KIRKLEES METROPOLITAN COUNCIL INVESTMENT & REGENERATION SERVICE

DELEGATED DECISION TO DETERMINE APPLICATIONS FOR CONSENT, AGREEMENT OR APPROVAL REQUIRED BY CONDITION

Reference No:	2025/44/92839/W
Site Address:	41, Ashbrow Road, Fartown, Huddersfield, HD2 1DX
Description:	Discharge of details reserved by condition 14 (on-site micro-generation) on previous permission 2022/90852 for erection of mixed use development of retreat building and 5 dwellings with integral garages
Recommending Officer:	Danielle Cooper

Officer Report

ROOF PLAN

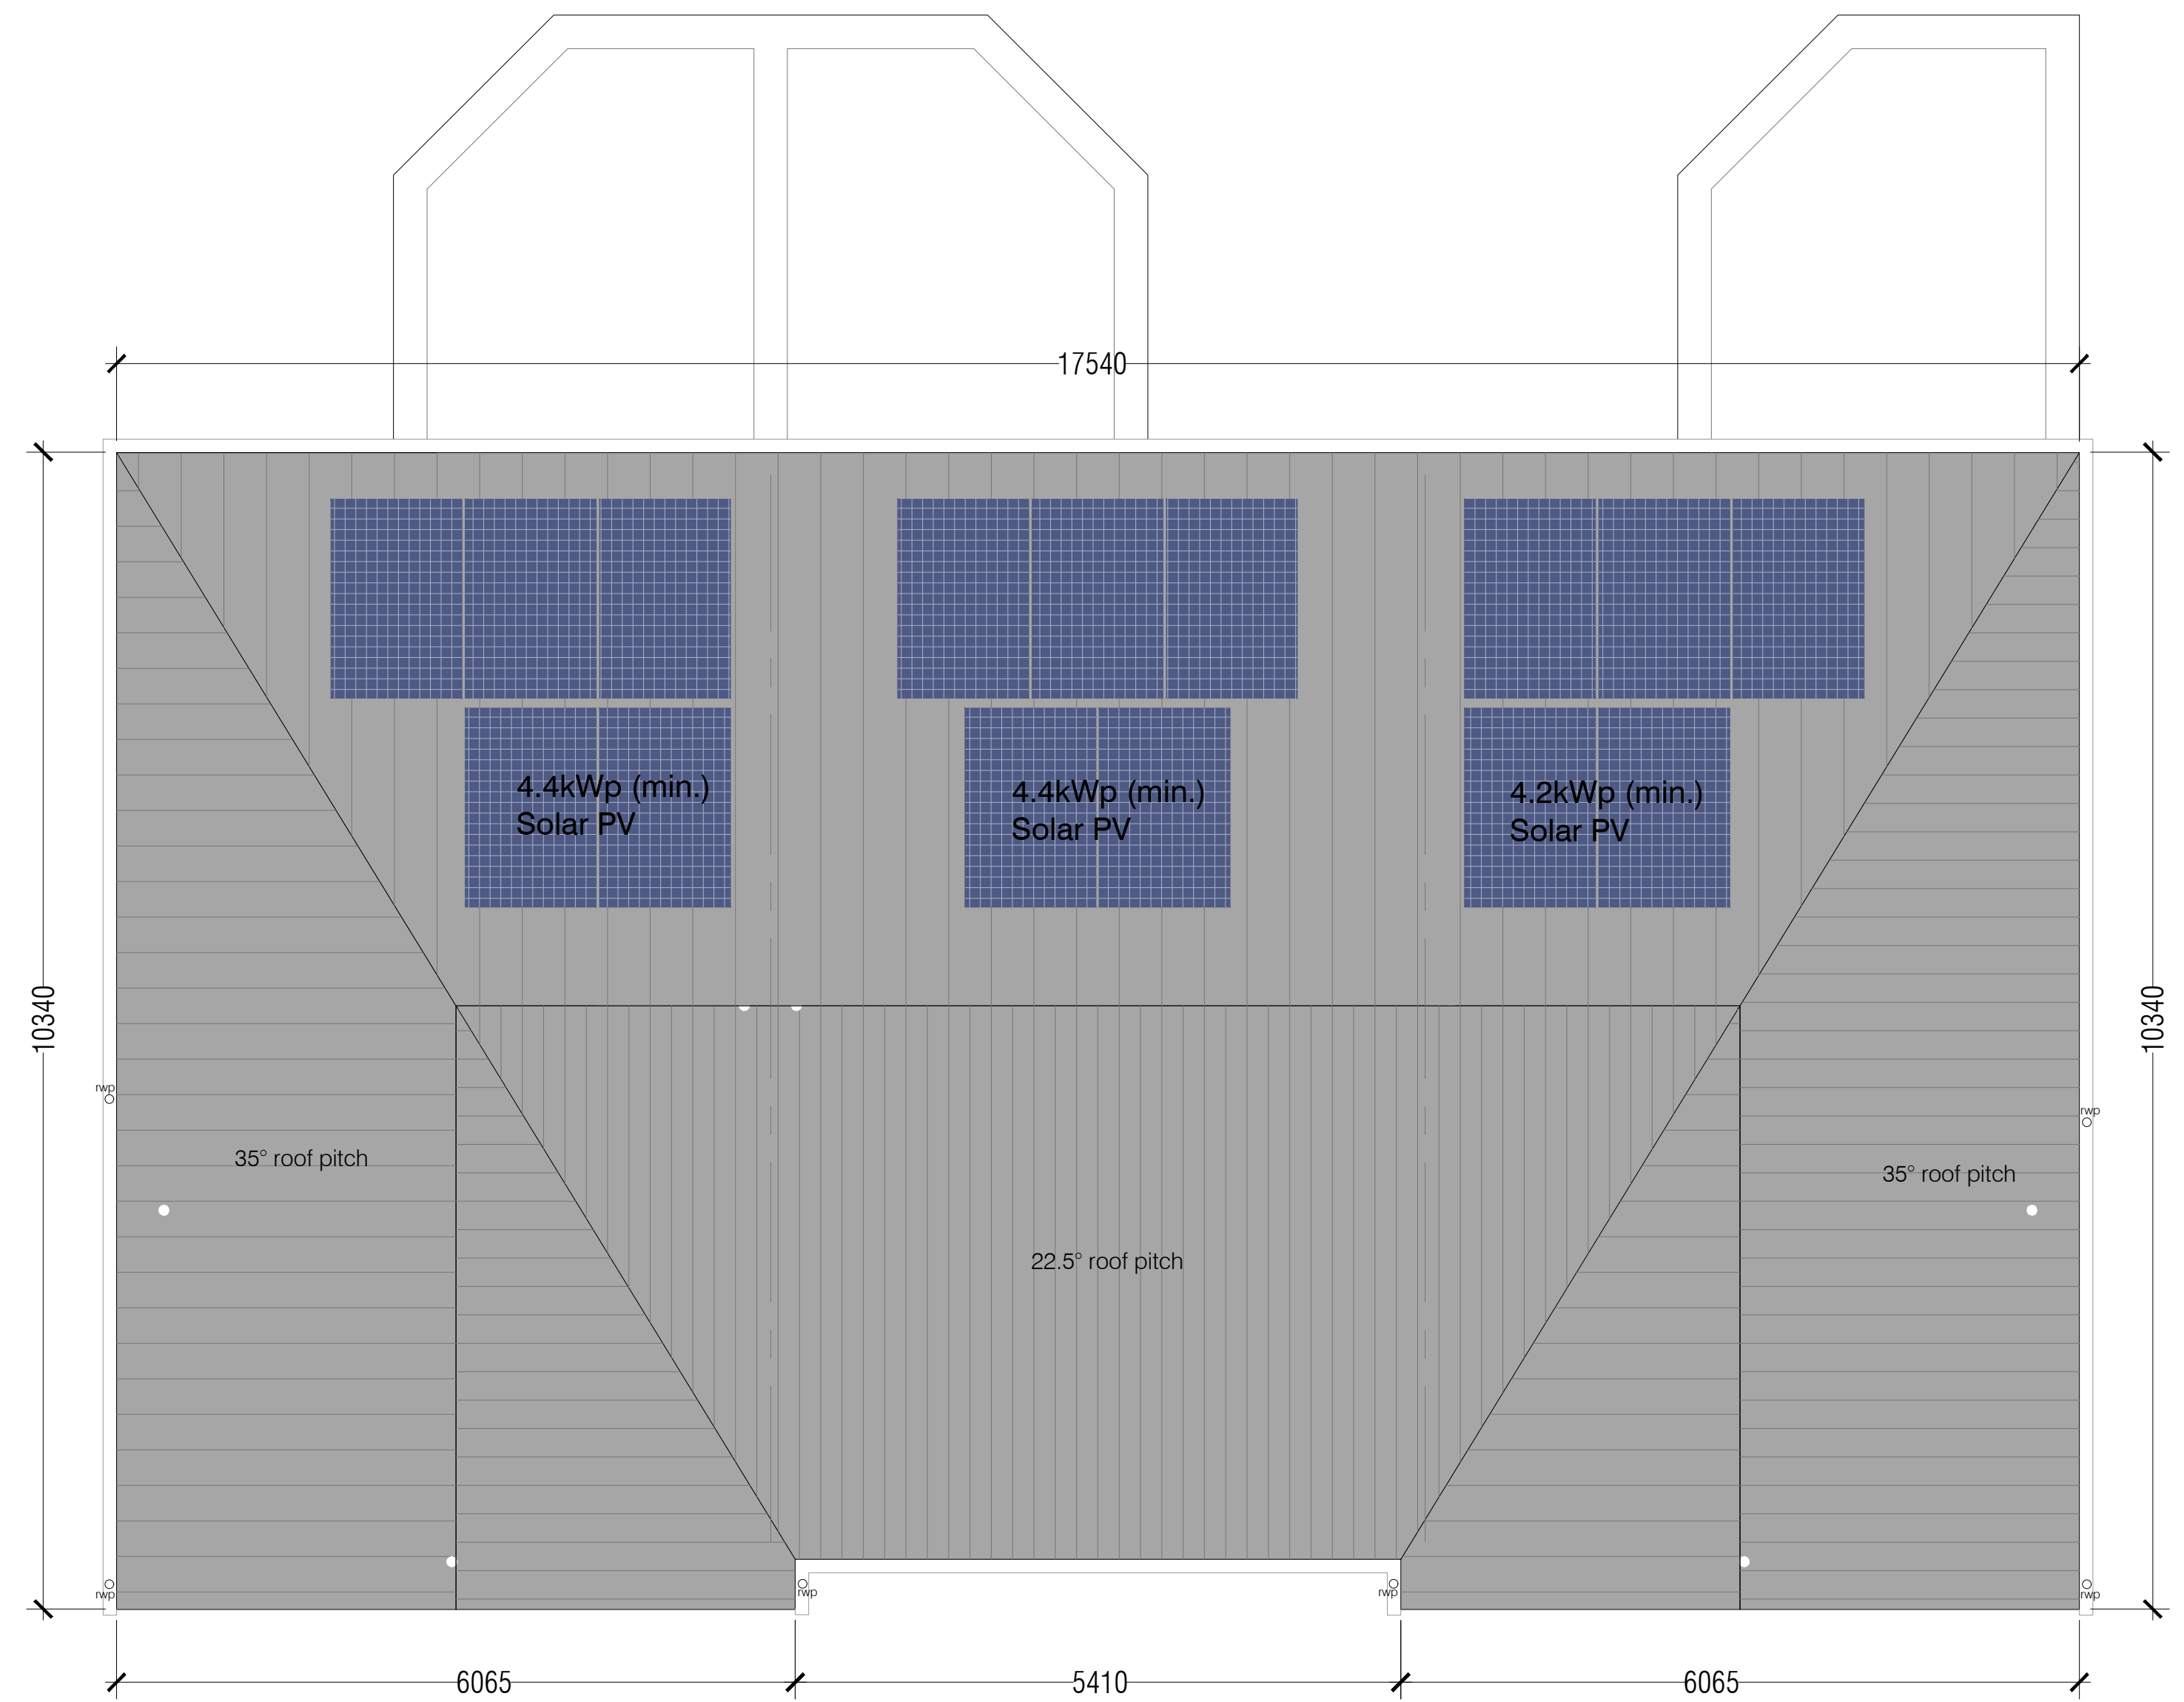
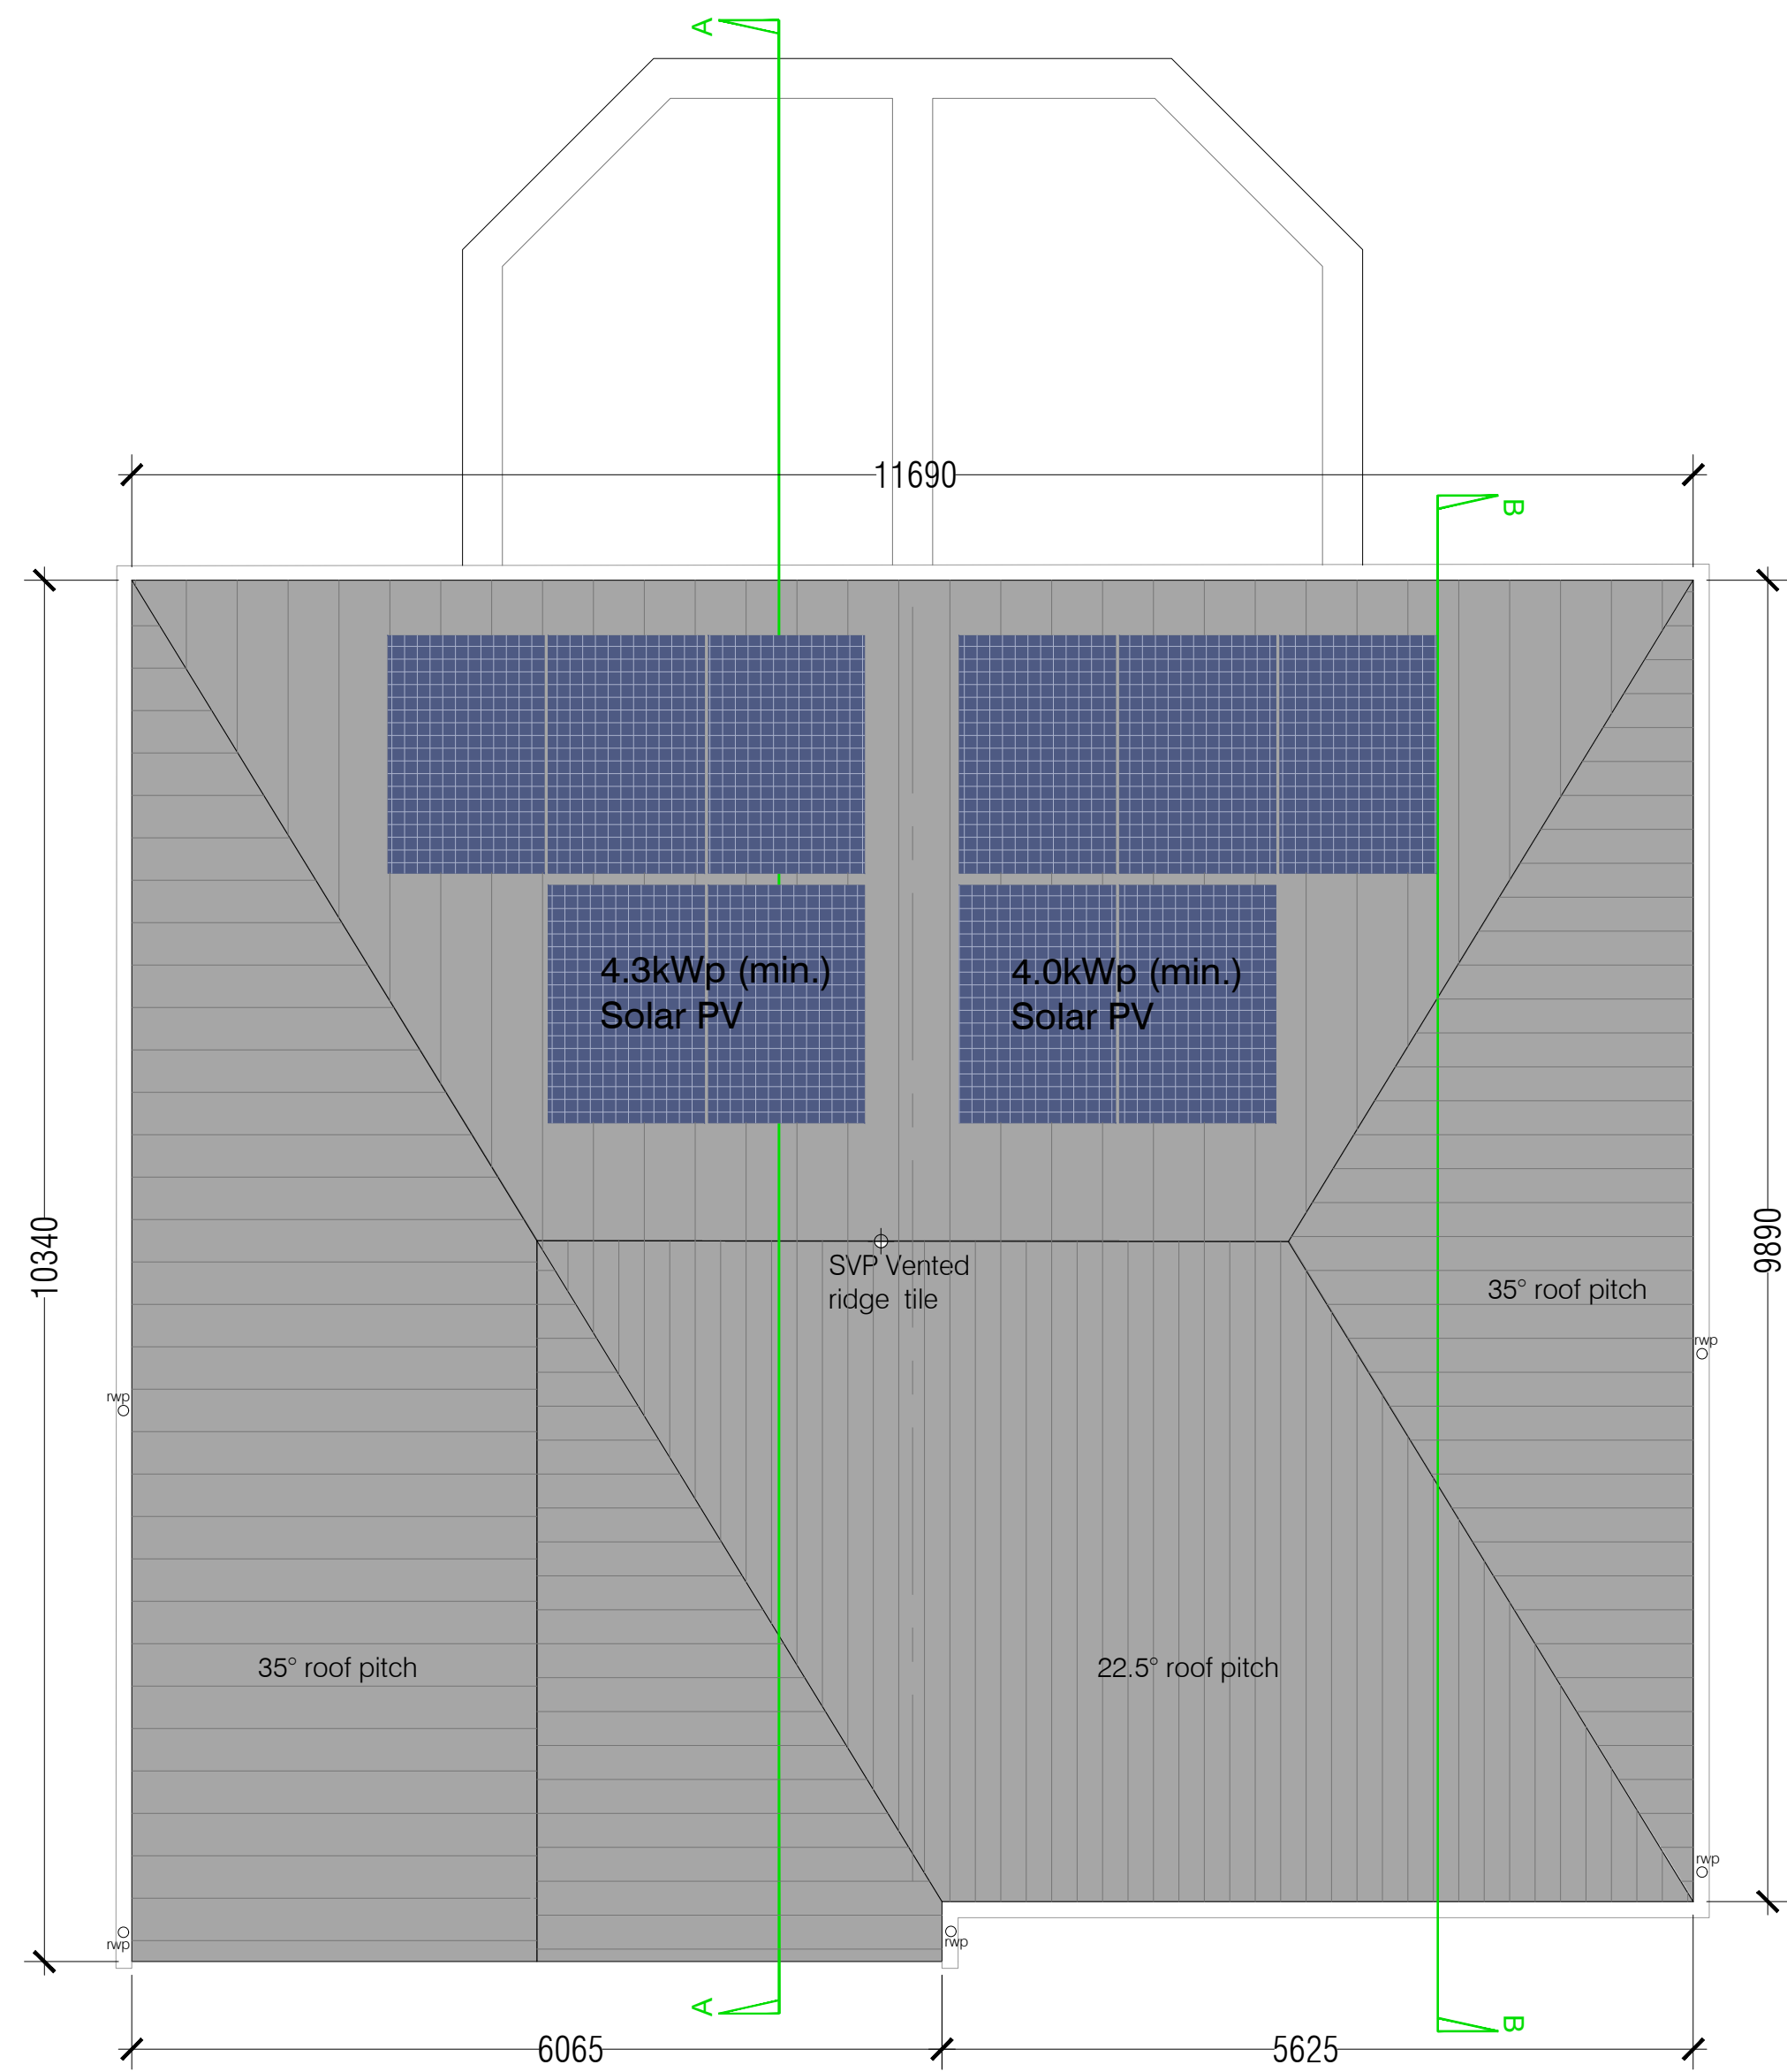
The proposal would see the use of insulation to walls, lofts / voids and would see the use of solar panels to all roof slopes of the dwellings. This would see a total of 25 solar panels provided. Five solar panels are annotated as being 4.2KWP (12 to 16 kWh (kilowatt-hours) per day on average). This would see a large proportion of the electricity consumption of each dwelling addressed by the solar panel installation upon each dwelling.

The extent of the carbon reducing technologies proposed and insulation to be installed to the walls and roof voids of the development is considered acceptable as a scheme to satisfy condition no.14 and the proposal is therefore recommended for approval.
